Our Ref: R/2025/16  
File No: 2025/553139  
Your Ref: SSD-75493483

**Advice on EIS – Forest Lodge Integrated Seniors Living – SSD-75493483**

Thank you for your correspondence dated 8 September 2025 inviting the City of Sydney Council (the City) to comment on SSD-75493483 for the alterations of the former hat factory and the construction of a 6-storey building to accommodate 71 independent living units, a 12-bed residential care facility, and associated amenity and parking, and the delivery of public open spaces and 2 through-site links.

Title
LEVEL 03

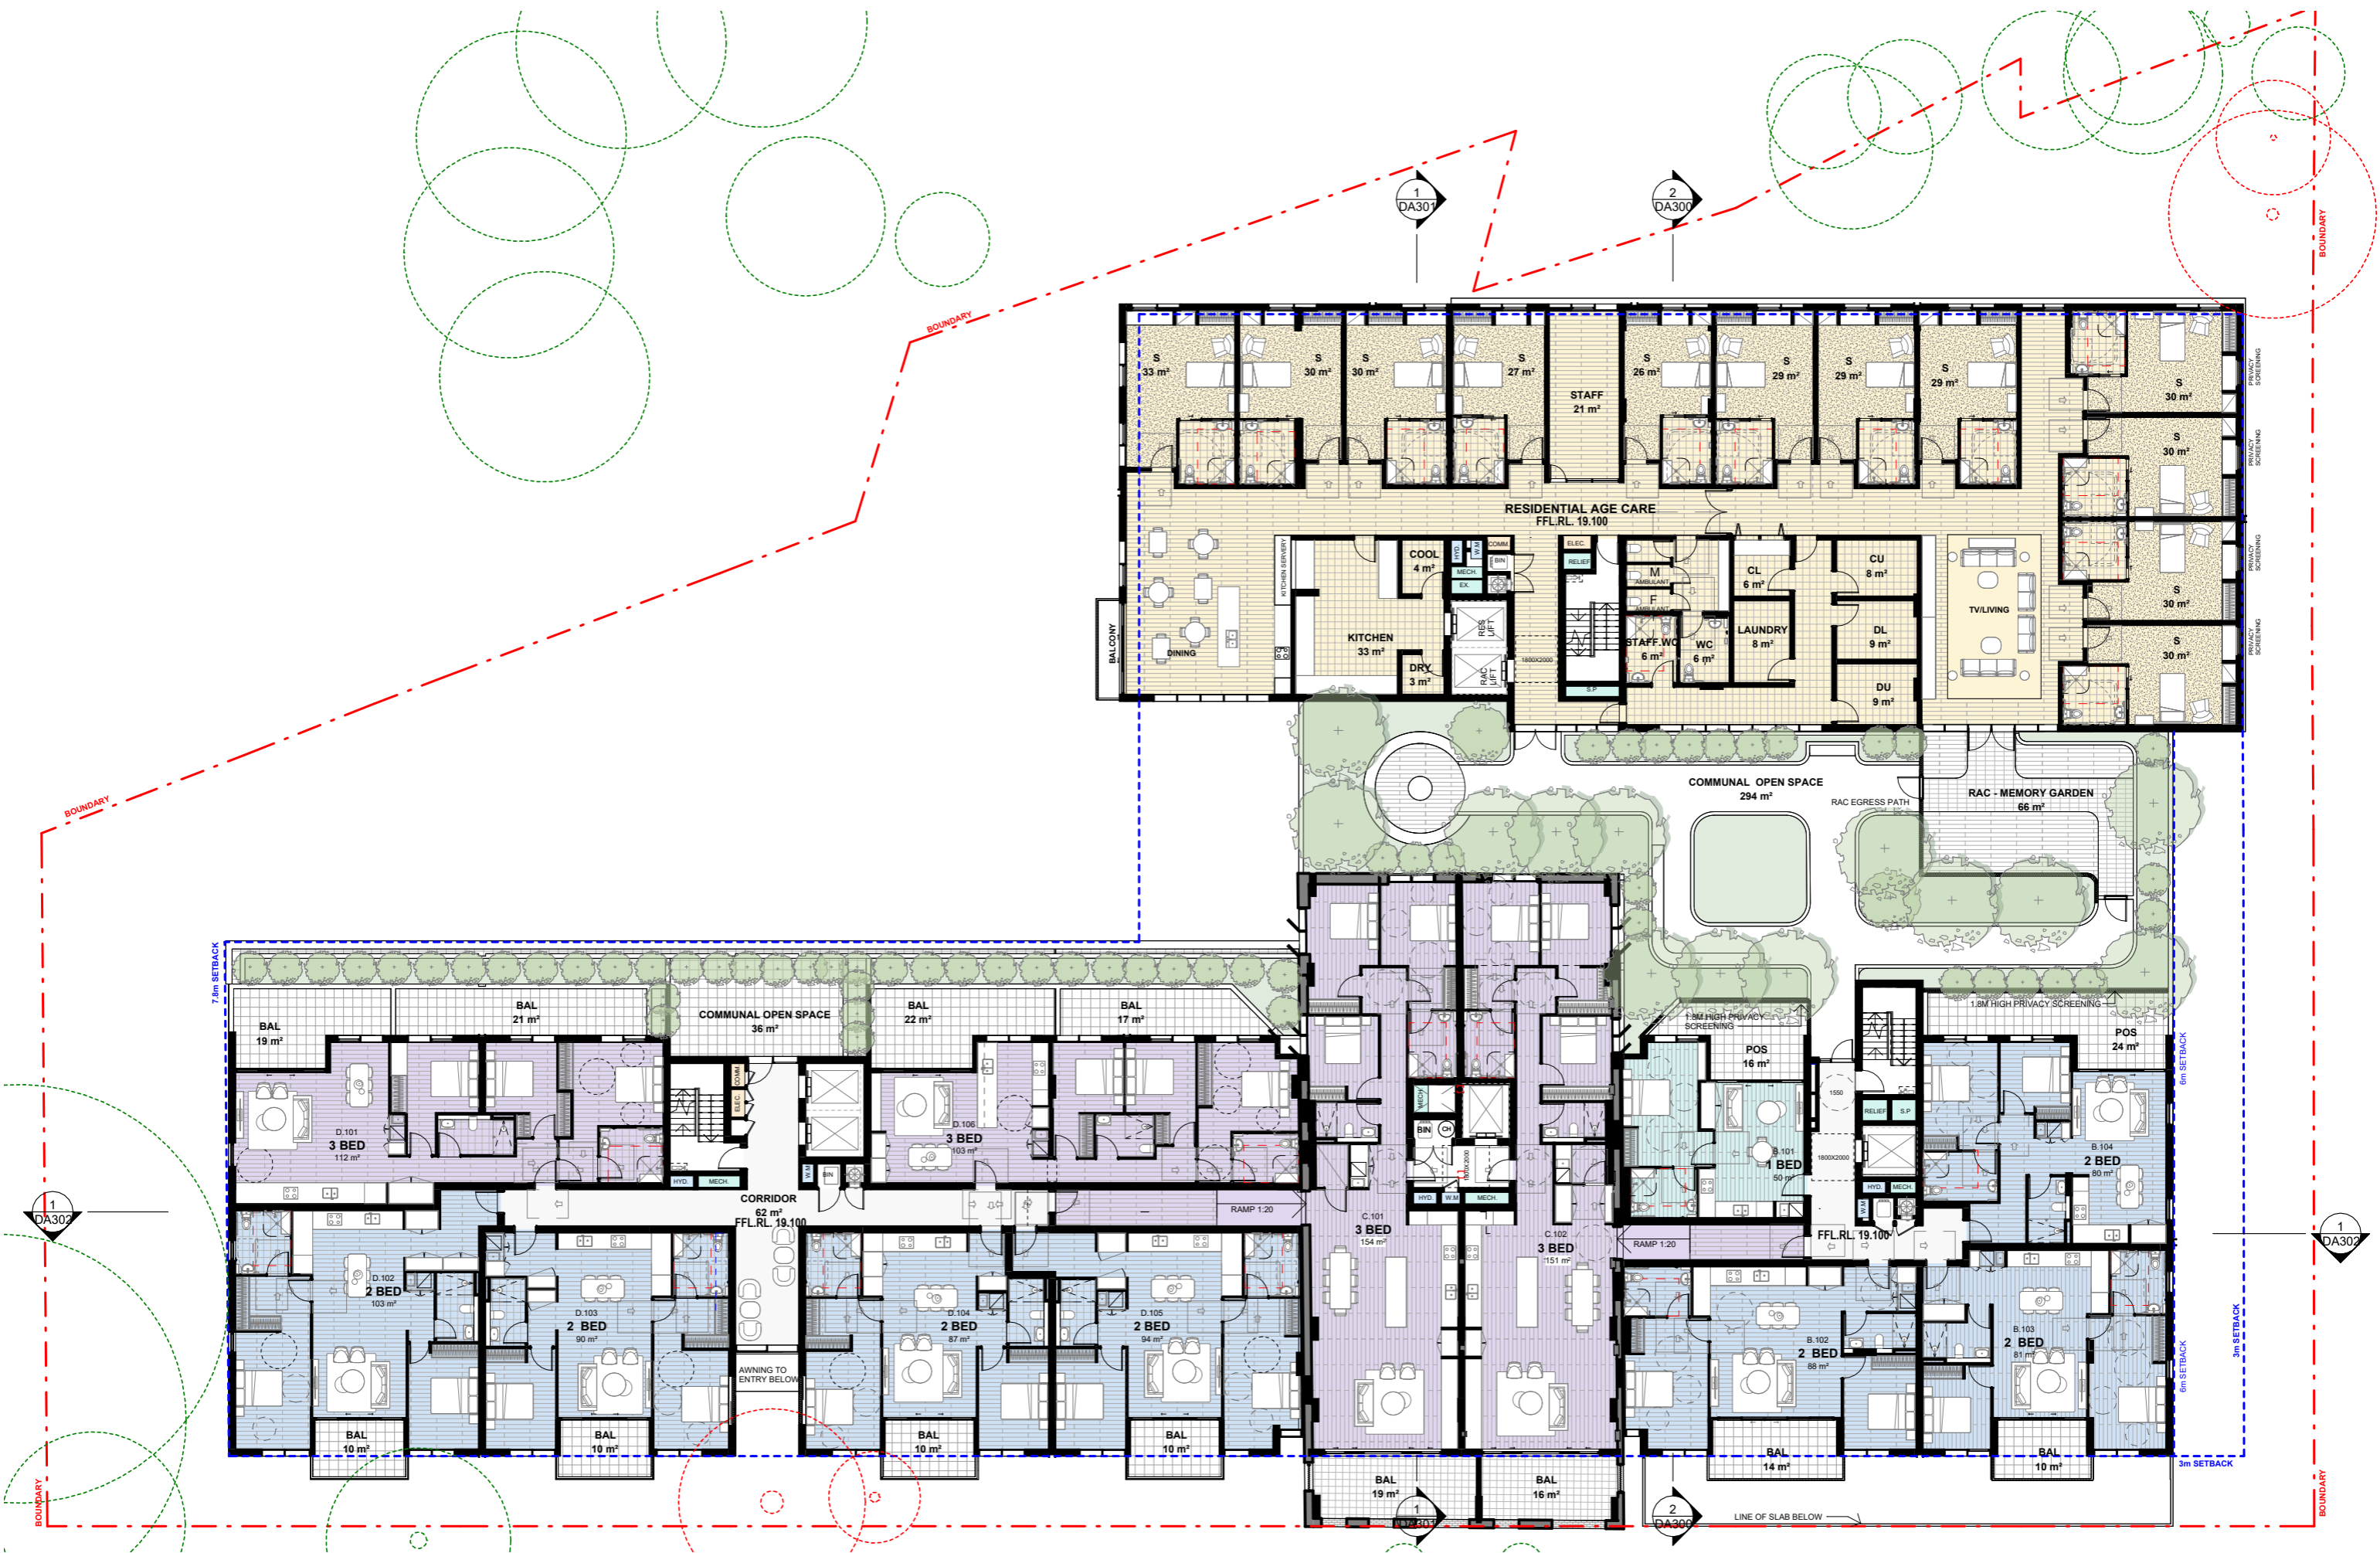
Due to their height relations, the balconies of B.401 and D.0404 may overlook the balconies of C.301 and D.404. The reduced building separation between the balconies of A.205 and B.204, and the balconies of A.305 and B.304, may result in potential privacy issues as well. These need to be balanced with the sense of enclosure and outlook afforded to each balcony. High screening would be inappropriate.

DRAINAGE CATCHMENT PLAN

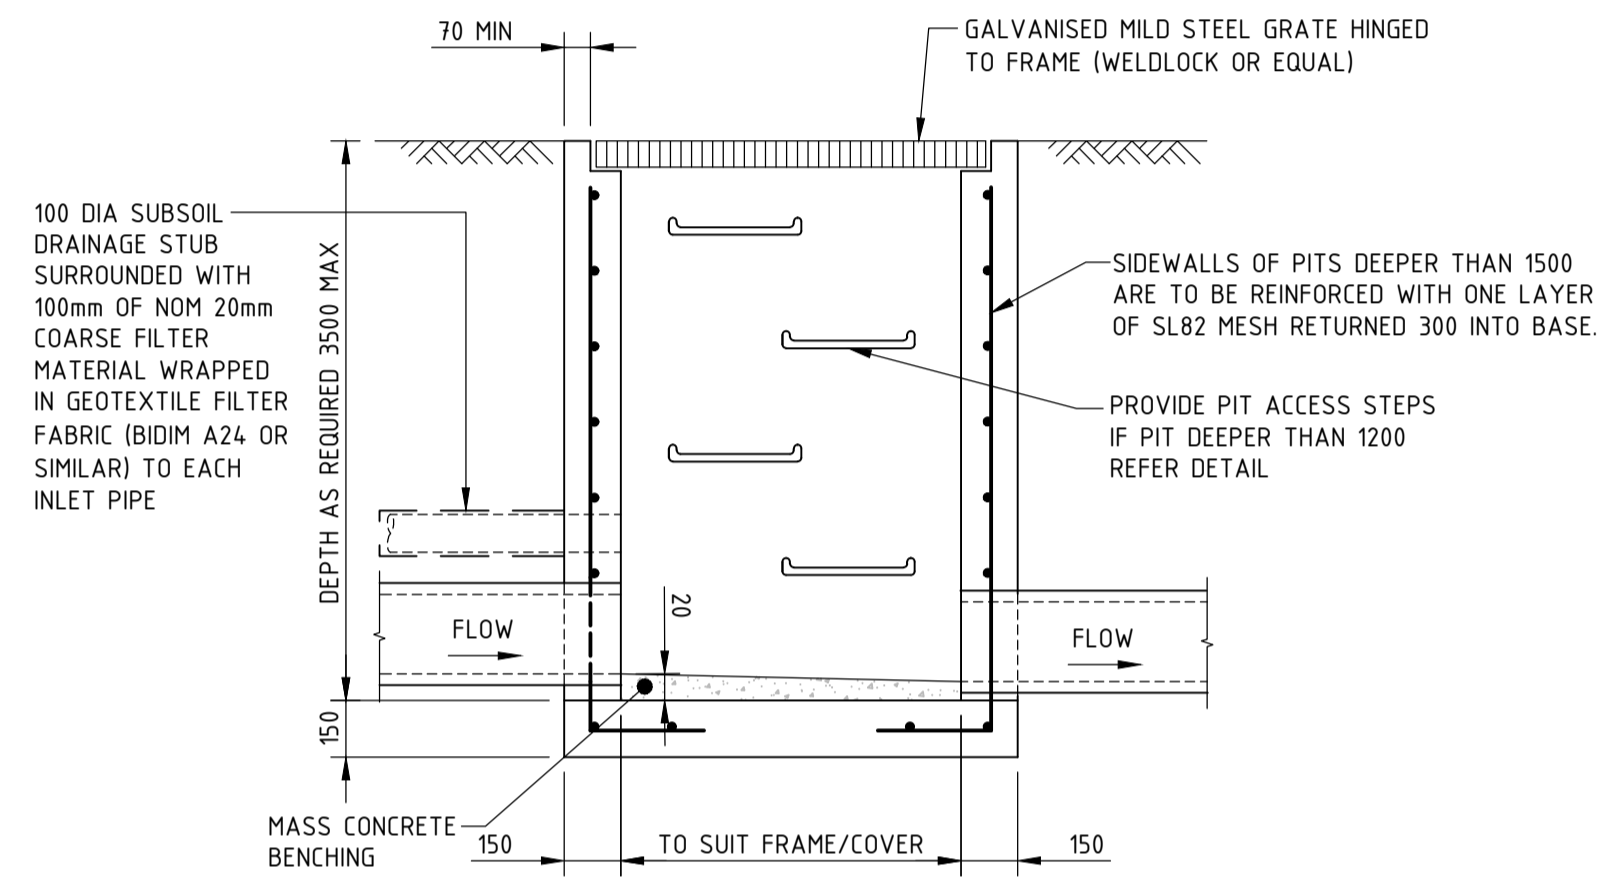
A Local Drainage Management Plan prepared by a suitably qualified and experienced drainage engineer is required. The LDMP must provide a comprehensive assessment of the site's drainage requirements and demonstrate compliance with Section 3.7.2 of Sydney DCP 2012.

The Local Drainage Management Plan must address the following matters:

- the site's hydrology and its relationship to the broader drainage system, the distribution of soil types and potential for onsite infiltration, expected groundwater impacts, and opportunities for onsite stormwater reuse
- how the proposal ensures public and pedestrian safety;
- document the design of both minor and major drainage systems, showing how stormwater flows will be managed for specified exceedance probability events and that connections to the downstream drainage network do not compromise existing infrastructure capacity.
